Application Ref:	3/2025/0189			 Ribble Valley Borough Council www.ribblevalley.gov.uk
Date Inspected:	18/4/25 & 27/5/25	Site Notice:	18/4/25	
Officer:	BT			
DELEGATED ITEM FILE REPORT:				REFUSAL

Development Description:	Demolition of existing 4 bedroom dwelling and construction of replacement 6 bedroom dwelling with integral garage.
Site Address/Location:	Moorcock House, Slaidburn Road, Waddington, Clitheroe, BB7 3AA.

Proposed North Elevation
Scale (1:100)

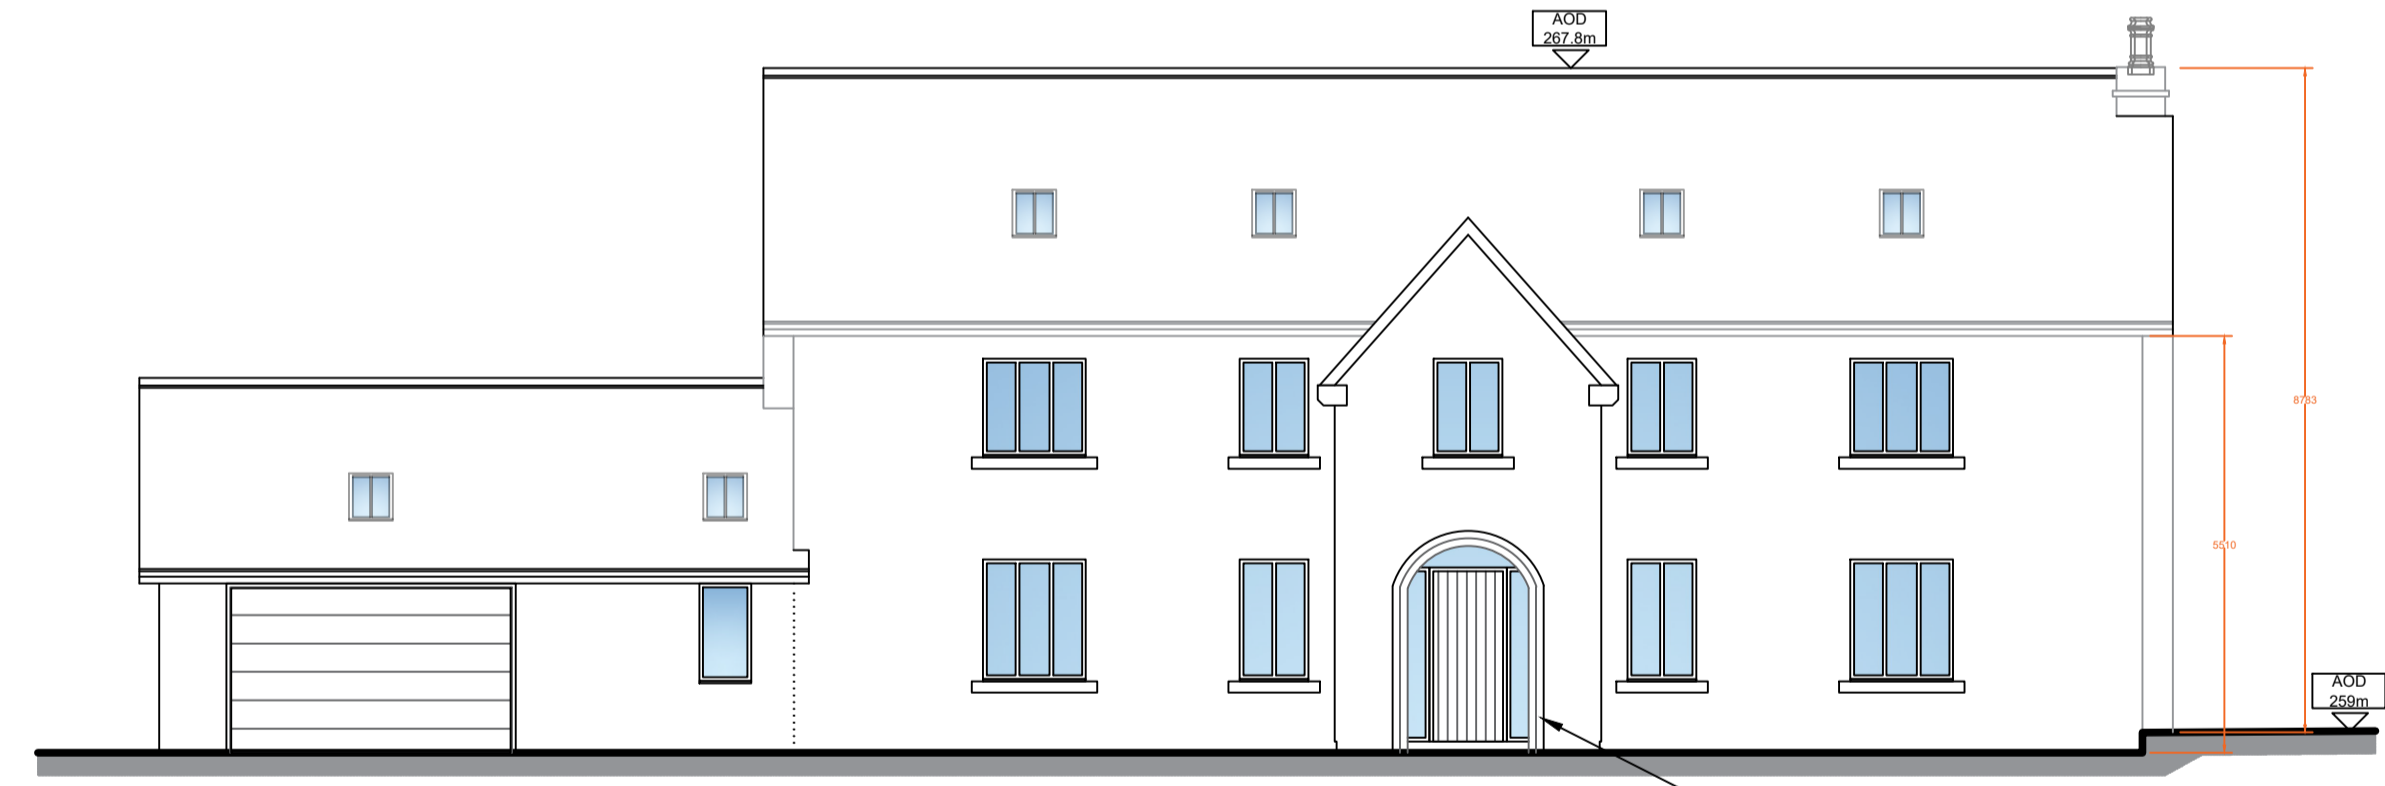
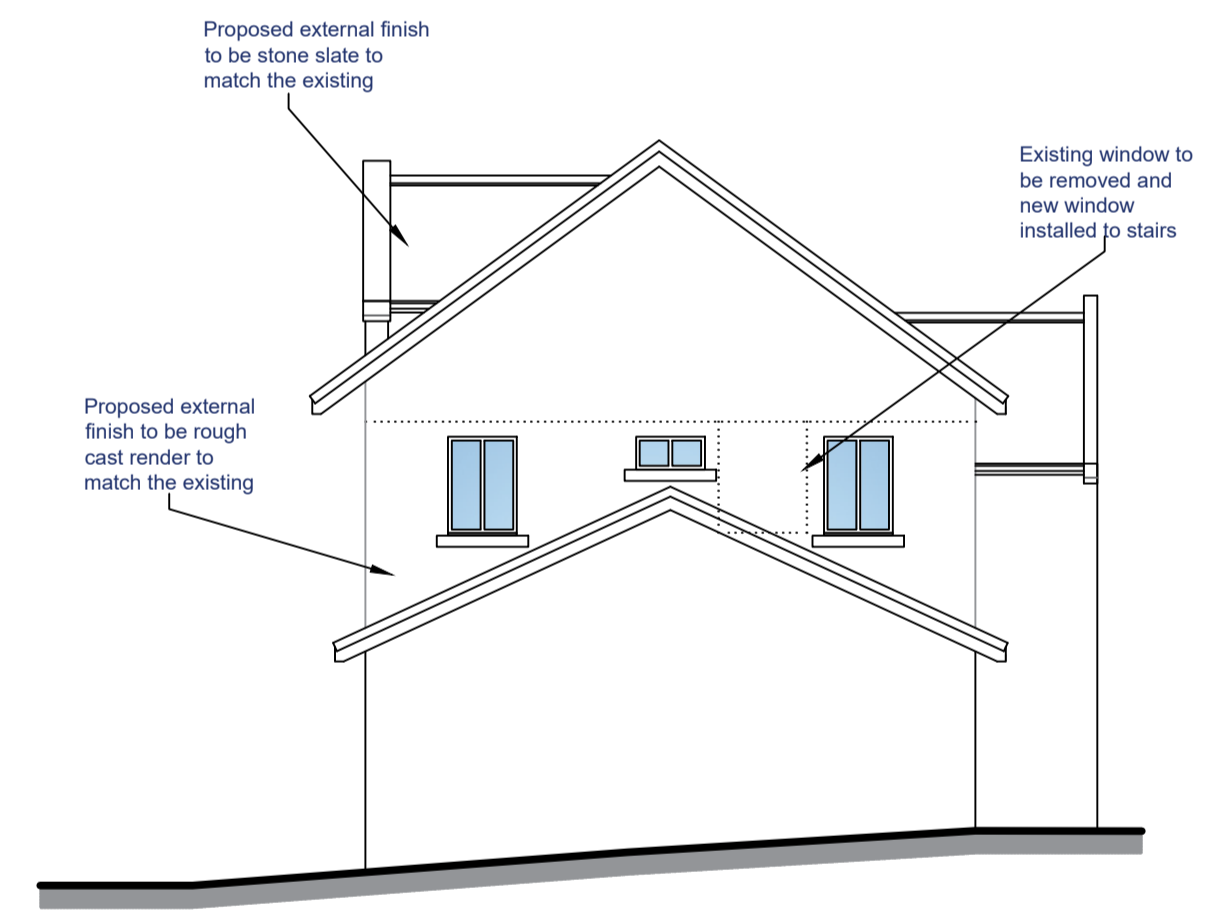
In contrast, the proposed dwelling would be a sizeable addition to the application site in terms of its width, bulk and massing with all of these exceeding the width, bulk and massing of the existing dwelling by a considerable measure. In addition, whilst it is noted that the width of the proposed dwelling would be similar to that of the adjacent neighbouring property of No.4 The Graces, the front and rear elevations of the dwelling's integral garage component (which would occupy roughly a third of the width of the proposed dwelling) would be aligned flush with the front and rear elevations of the host property which in turn would exacerbate the width, bulk and massing effect of the proposed dwelling. Furthermore, the integral garage component of the proposed dwelling would incorporate a gabled roof profile that would be symmetrically at odds with the sloping gradient of the host dwelling, with the roof slopes and roof apex of the integral garage sited directly underneath first floor window cills resulting in a somewhat cramped spatial arrangement. Moreover, whilst the proposed dwelling would comprise an almost identical height to that of the existing dwelling's highest roof slope, the extent of the proposed dwelling's roof ridgeline would span across approximately two thirds the width of the proposed dwelling which in turn would accentuate the dwelling's cumulative bulk and massing effect.

Taking account of all of the above, it is considered that the proposed replacement dwelling by virtue of its scale, bulk, massing, width, height and fenestration would amount to an over dominant, unsympathetic and incongruous form of development that would be at odds with the prevailing character of residential development within the immediate locality. Accordingly, it is considered that the proposed development would be harmful to the visual amenities of the area and for this reason it is not considered that the proposal would in this instance conserve or enhance the character of the surrounding National Landscape. The proposal would therefore fail to satisfy the requirements of Paragraphs 135 (C) and 189 of the NPPF and Key Statement EN2 and Policies DMG1 and DMG2 of the Core Strategy.

Proposed South Elevation
Scale (1:100)

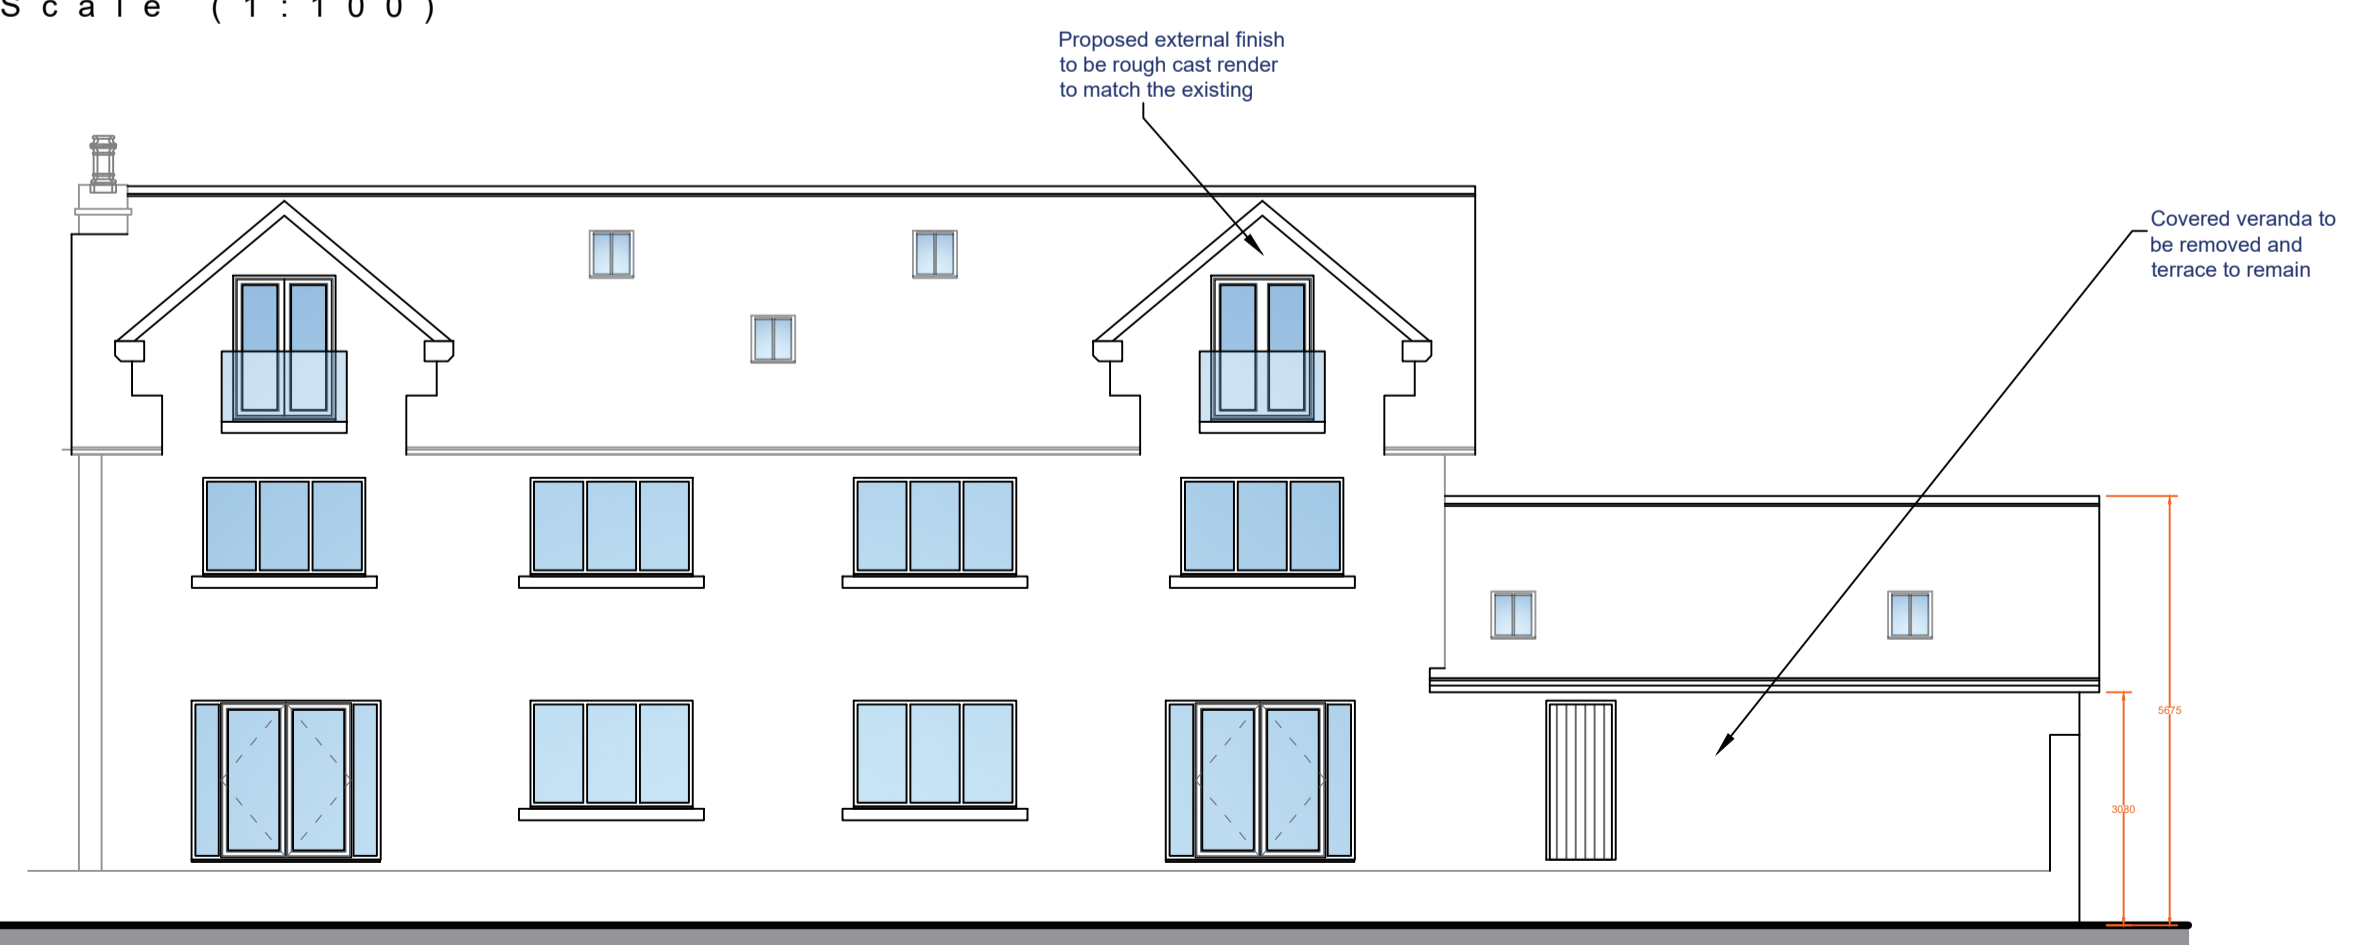
Projecting gable features are also proposed for the Southern roof slope of the proposed dwelling. Whilst the roof apexes of the projecting gables would be set just below the roof line of the proposed dwelling, the faces of the projecting gables would be aligned flush with the dwelling's Southern elevation, with the eaves level of the projecting gables sited above the eaves level of the proposed dwelling, and with no setback incorporated into the central area of the dwelling's principal elevation to differentiate the projecting gable features from the remainder of the dwelling. As such, the projecting gable features would further increase the bulk and massing effect of the proposed dwelling.

Numerous window openings are proposed for the principal Southern elevation of the proposed dwelling. Whilst the cumulative extent of glazing proposed would not be excessive, the proportionality of the window and door openings proposed would be largely uniform across the frontage of the dwelling, with no differentiation in terms of a descending solid to void ratio of openings incorporated between the ground floor and second floor levels of the property's principal elevation which in turn would be noticeably at odds with the sequencing of fenestration within the principal elevations of the application property and adjacent neighbouring properties of The Graces.
